**Consultation Response from: KC Environmental Health (Pollution & Noise Control)**
**2024/93485 - Shaw Cross House, Shaw Cross Business Park, Shaw Cross, Dewsbury, WF12 7RF**
**Discharge of details reserved by conditions 4 (Phase I Desk Study Report) , 5 and 6 (Phase II Intrusive Site Investigation Report), 9 (Charging Facilities) 10 (Public Sewerage Infrastructure ) on permission 2023/93273 for erection of two storey rear extension and extension to car park**
**Date Responded:**  
**14<sup>th</sup> January 2025**
**Responding Officer:**  
**NH**
**Responding Ref:**  
**WK/202440698**

A proposed site plan by Martin Walsh Architectural (drawing no. HSSB MWA XX XX DR A 0003 P2) has been received in support of the application to discharge Condition 9. The

Title: Proposed Site Plan

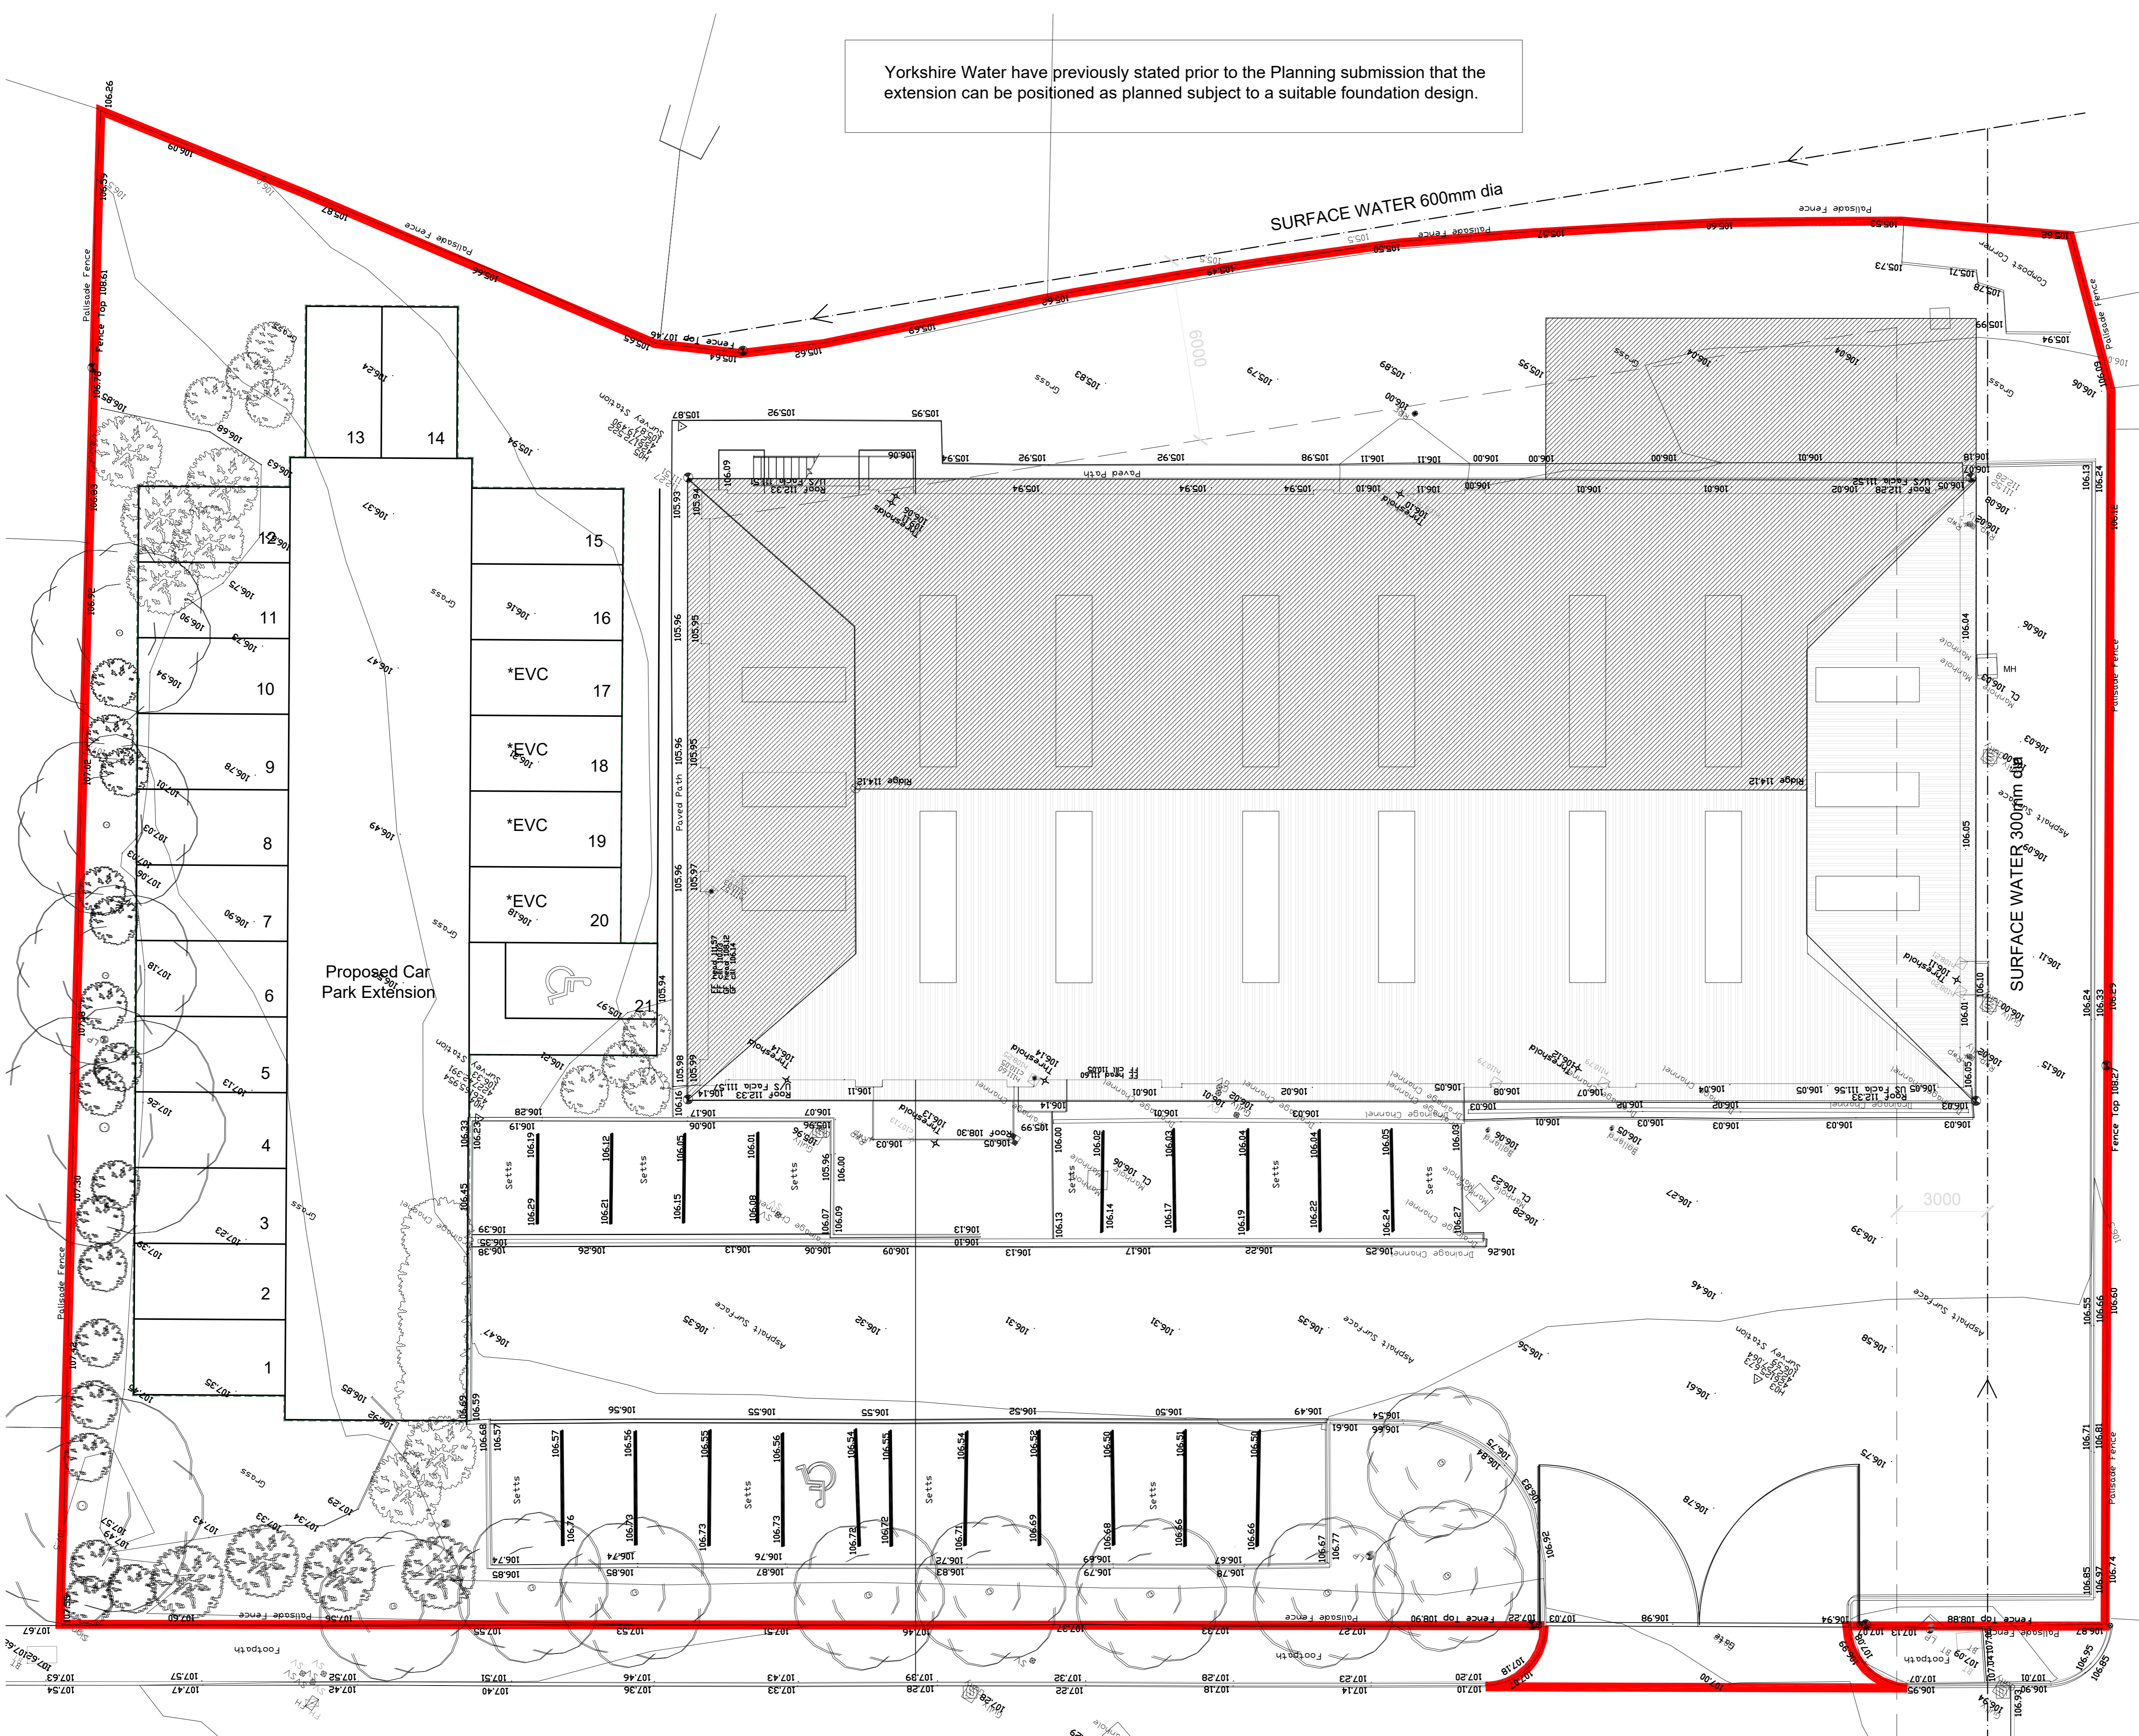
drawing shows four electric vehicle charging points in the extended car park area, which is accepted. However, no technical specifications have been provided to confirm that the charging points meet the minimum requirements as specified in the West Yorkshire Low Emission Strategy (WYLES) guidance. Therefore, further information is required before we can consider the application further.

No technical specifications have been provided to confirm that the charging points meet the minimum requirements as specified in the West Yorkshire Low Emission Strategy (WYLES) guidance. Therefore, further information is required before we can consider the application further.
